Engineers Comments Regarding Surface Water Drainage

Application Reference:	LU/98/26/PL	Reviewer Reference:	ADC/EXT5/AF
Planning Officer:	Kathryn Welch	Date of Review:	16/07/2026
Site Name:	16 Swanbourne Road Littlehampton BN17 6HS		
Application Description:	Erection of 1 No single storey dwelling with car parking and provision of driveway and car parking for No. 16 Swanbourne Road (resubmission following LU/96/25/PL). This application is in CIL Zone 4 and is CIL Liable as a new dwelling.		
Assessment Number:	2

Key  - BOREHOLE	Drawn	CB		Client: CGS CIVILS LTD		
	Approved	JO		Project: GROUNDWATER MONITORING WELL INSTALLATION 16 SWANBOURNE ROAD, LITTLEHAMPTON		
	Date	19/11/2025				
	Scale	NTS		Title: INVESTIGATION LOCATION PLAN		
	Original	A3		Project no: NN2075	Figure no: FIGURE 1	Rev: 1

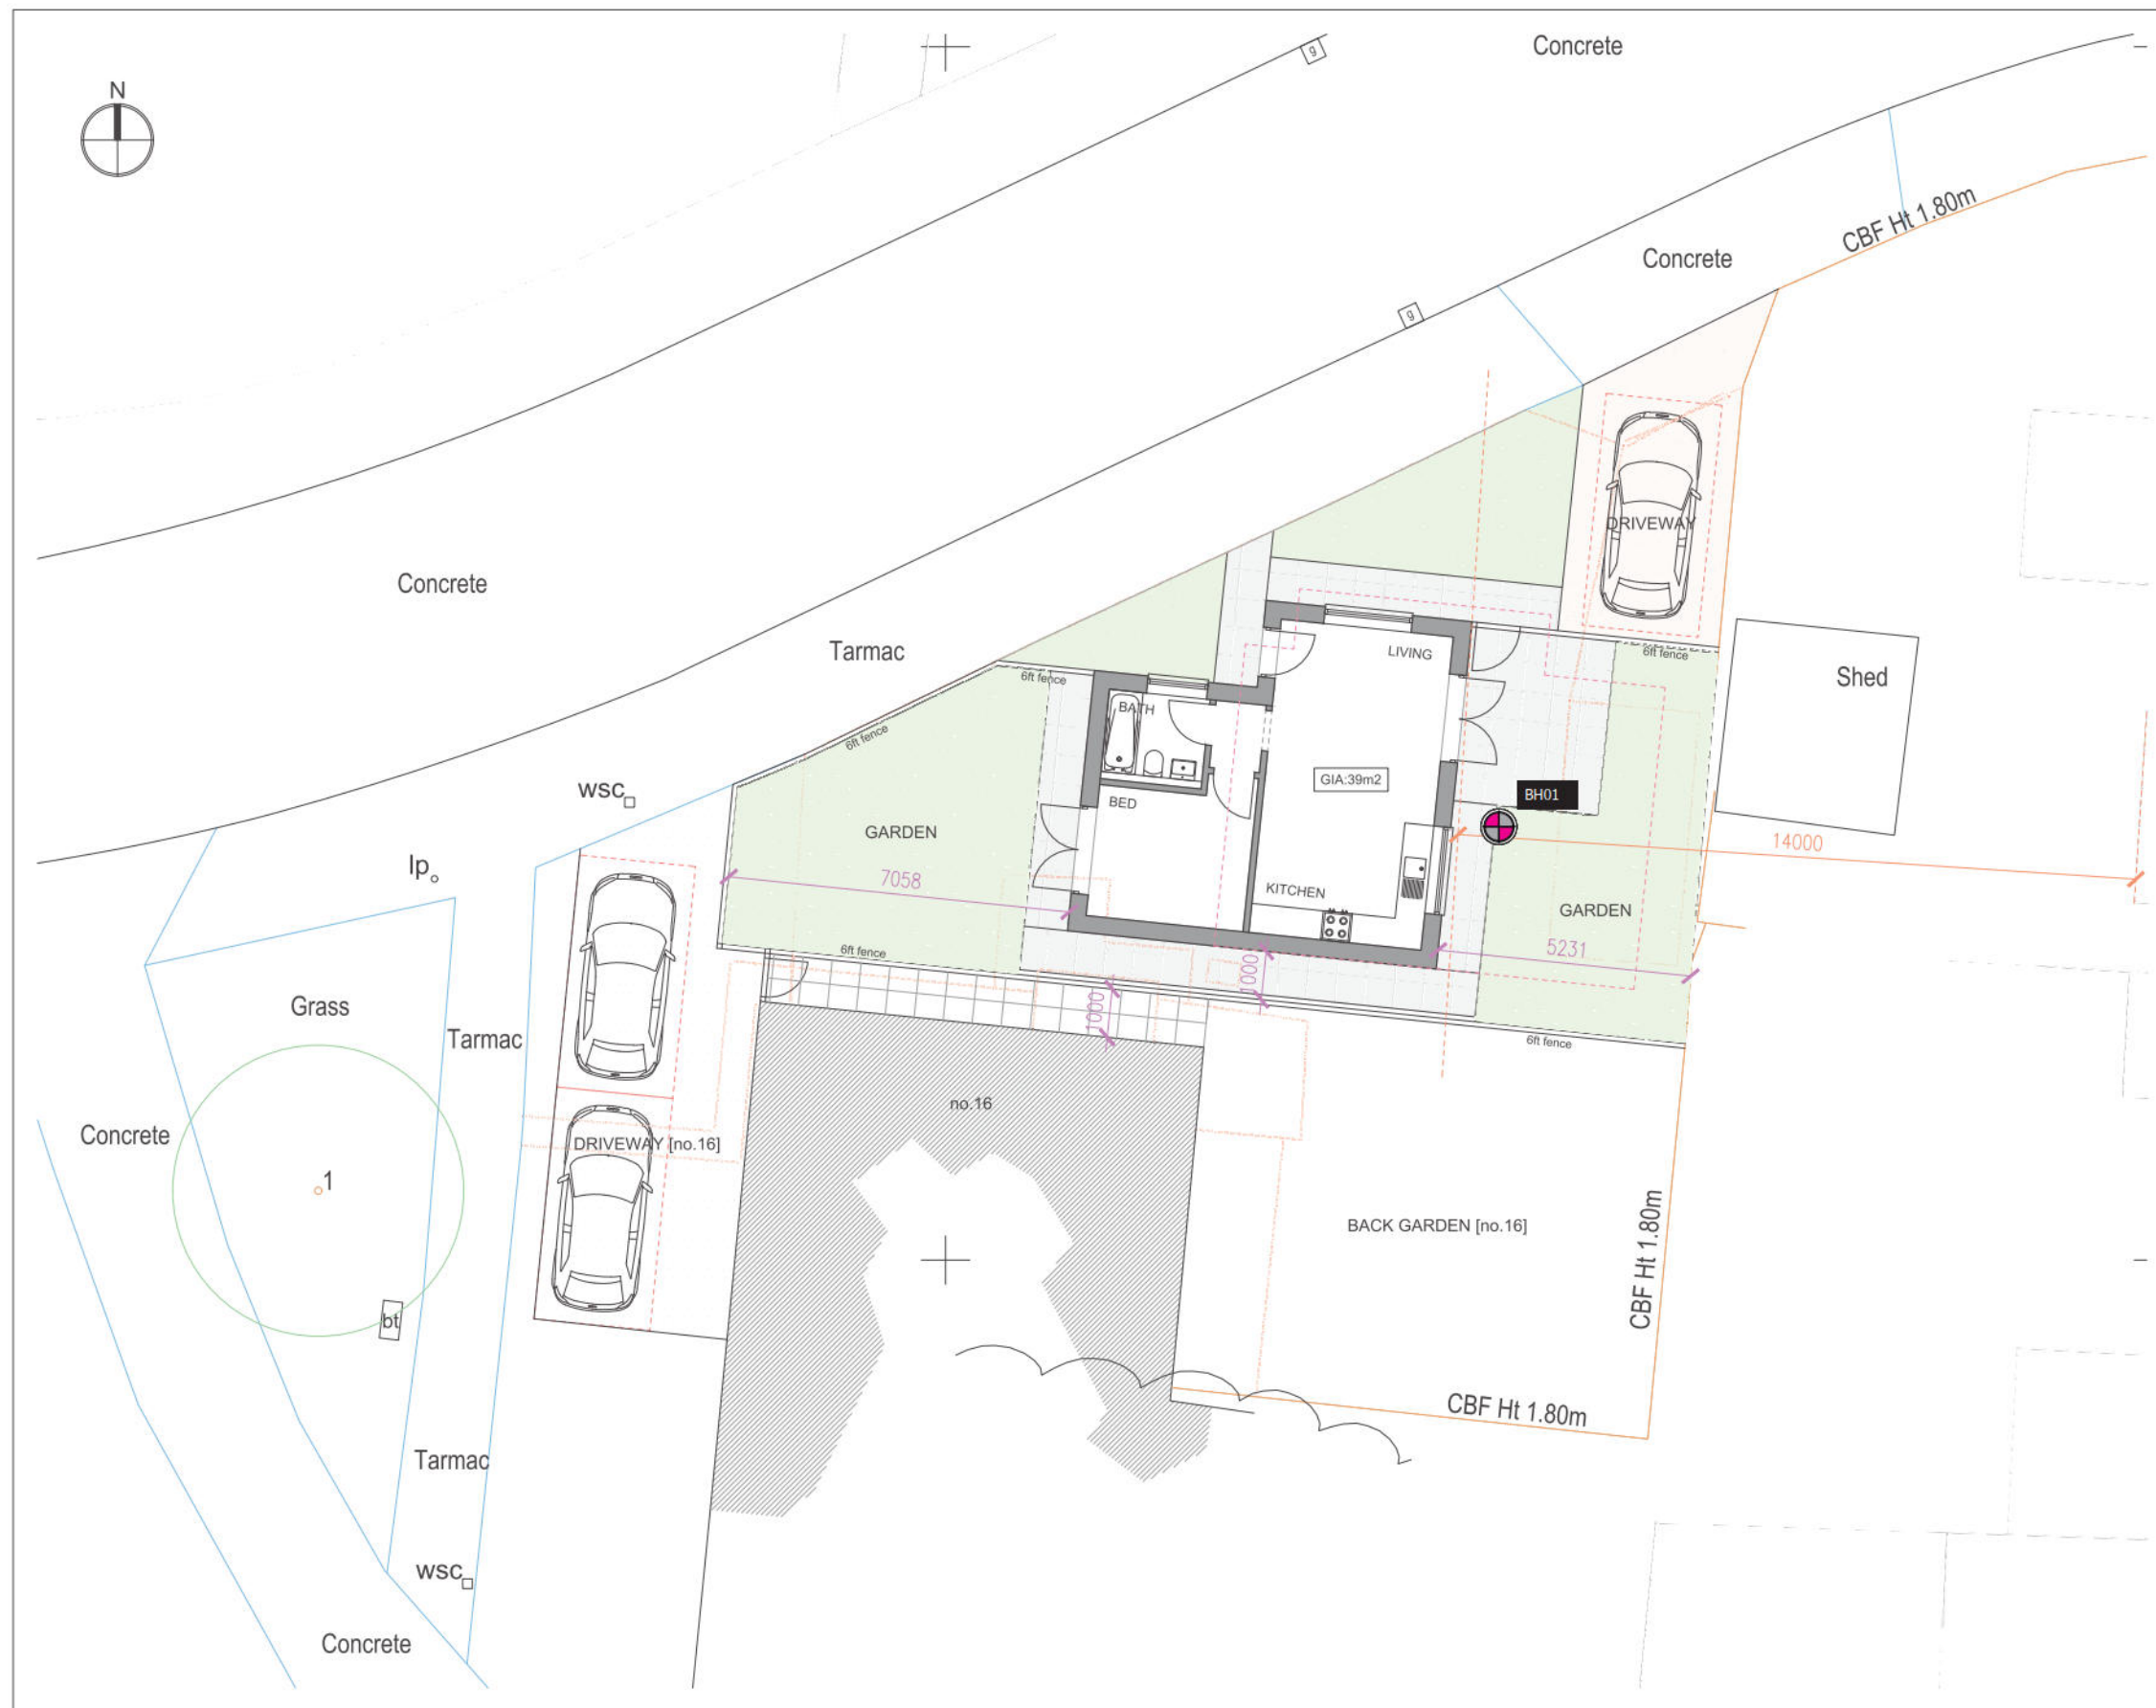
- 1.4. The groundwater monitoring measurements are only every two weeks and therefore do not accord with the ADC ground investigation checklist requirements. However, the results are sufficiently robust to demonstrate groundwater levels are comfortably below the 1m vertical buffer from the proposed base of soakaways.

PP1
Proposed Permeable paved Construction
(Design based on assumed CBR > 3%)
(Final subbase depth subject to CBR test)

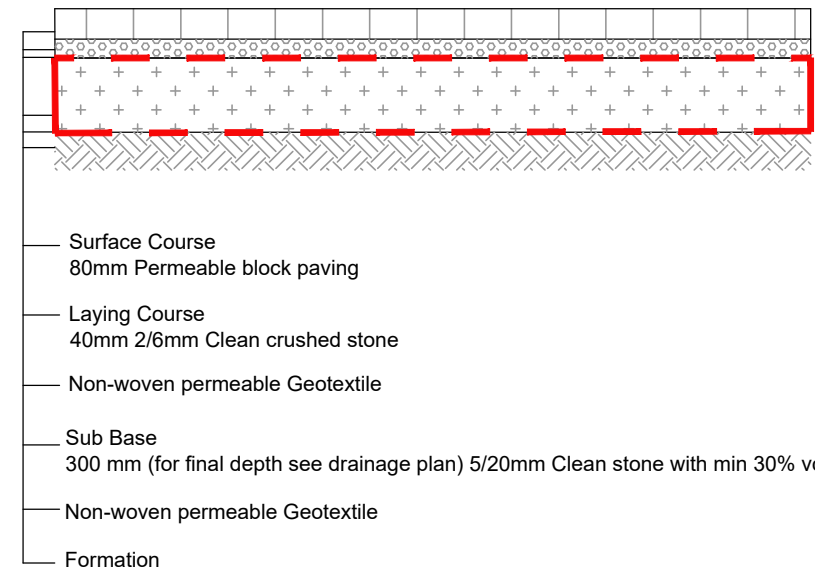
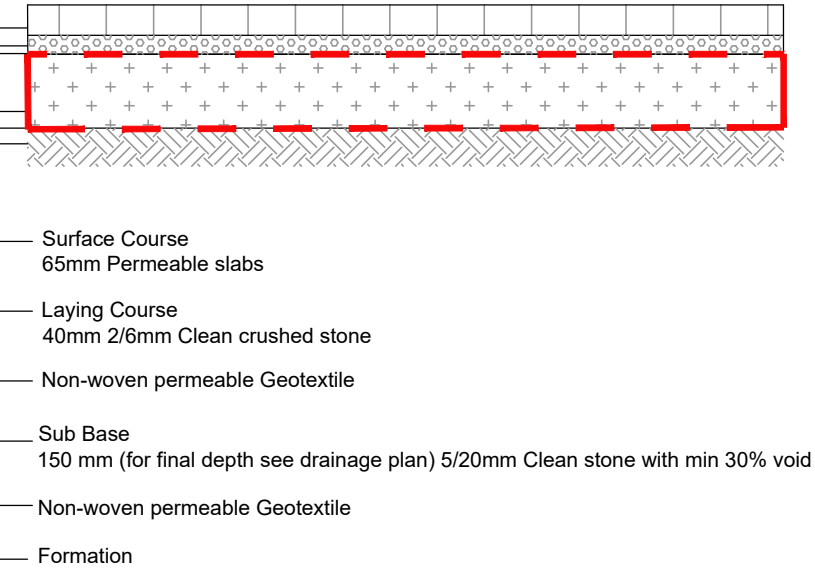
- 1.6. The ground investigation is acceptable to demonstrate the development can discharge to ground via infiltration. The two areas of permeable pavement have an infiltration base at different locations and depth to the single infiltration test and therefore further testing is required at discharge of conditions stage and condition wording is included in our comments below. Further winter groundwater monitoring is not required.

- 1. Detailed drainage plans conforming to Local Planning Authority guidance,
- 2. Specifications for all surface water drainage components and associated infrastructure or flow control mechanisms,
- 3. Infiltration testing strictly in accordance with BRE DG 365 or Ciria R156 Guidance,
- 4. Impermeable area plan,
- 5. Calculations modelling the surface water drainage network for the following storm events: a.) 100% Annual Exceedance Probability, b.) 10% AEP + climate change allowance, c.) 3.3% AEP + climate change

Proposed Downpipe Filter Chamber with discharge connection to SW drainage

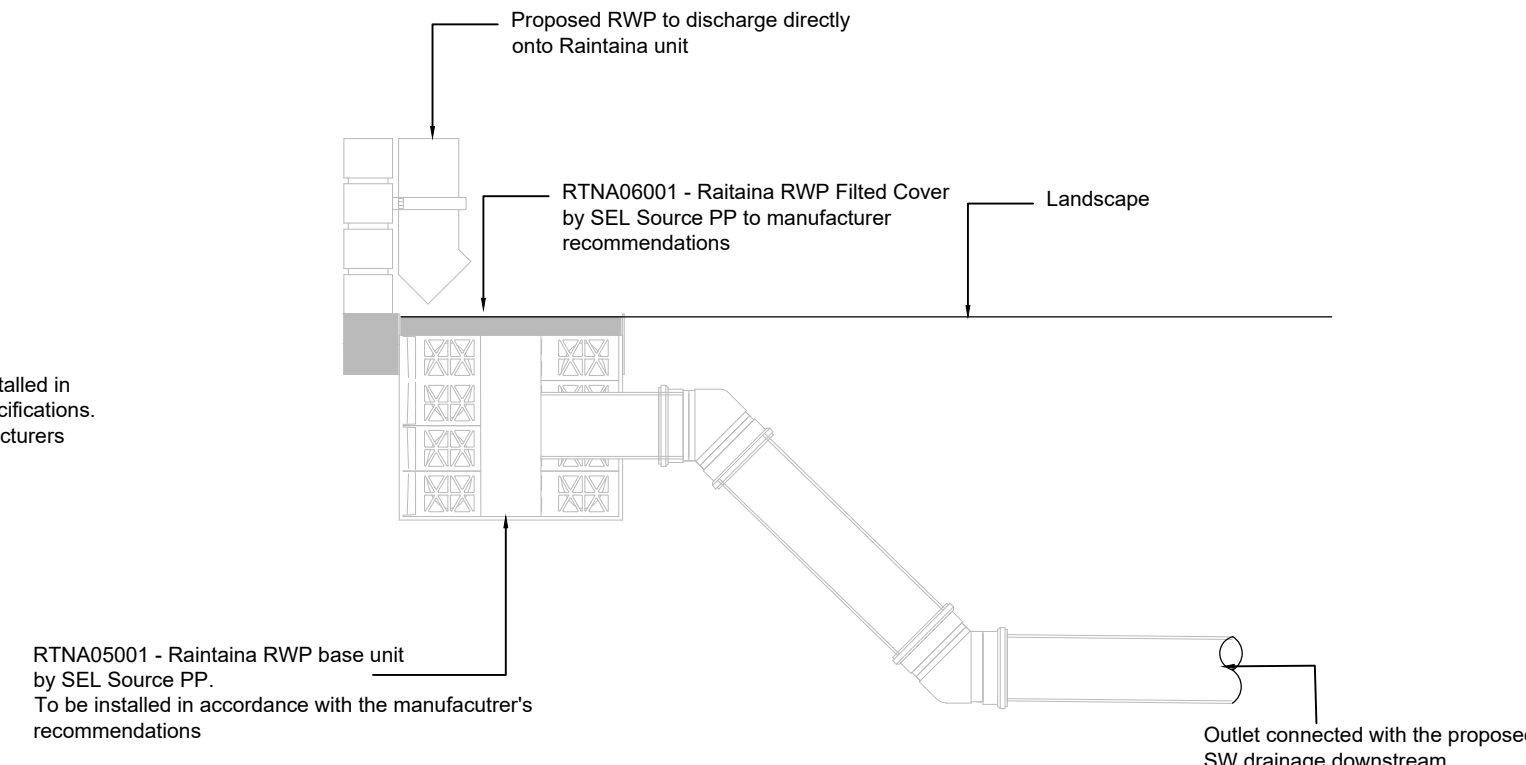
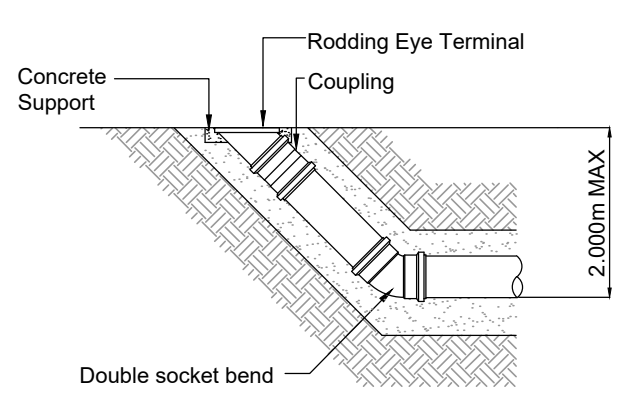
- 4.1. The water pollution indices risk is low and water quality mitigation is provided by permeable pavement and filter drains / filter chambers, which meet the standards set out in the Simple Index Approach.
- 4.2. Water quality is acceptable.

Trench soakaway using Polystorm-R Geomodular units

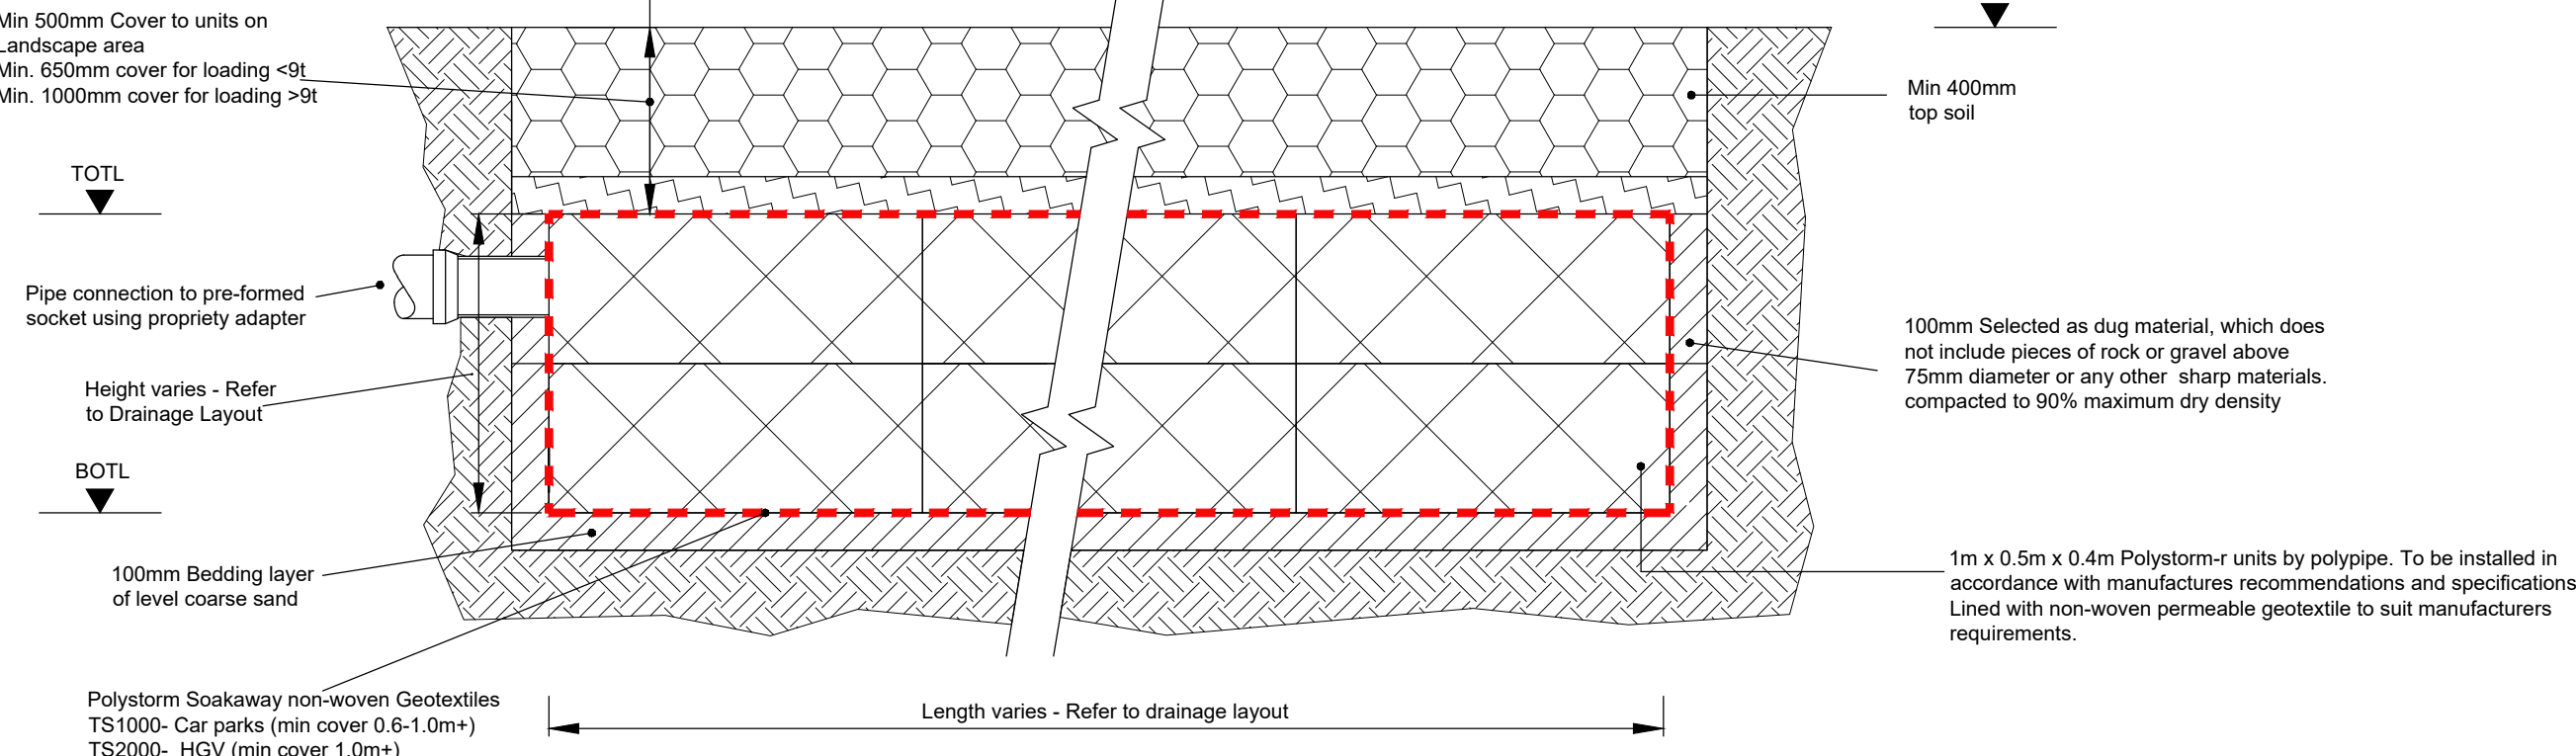
- 7.1. The dwelling will share a surface water drainage system with the existing house and the soakaway will be on third party land once the new dwelling is sold. The proposed soakaway is not within the planning red line boundary but is within the land ownership of the existing house as outlined on the Location Plan and rights of discharge will need to be included in the deeds.
- 7.2. A maintenance plan is provided which is acceptable for a single dwelling development.
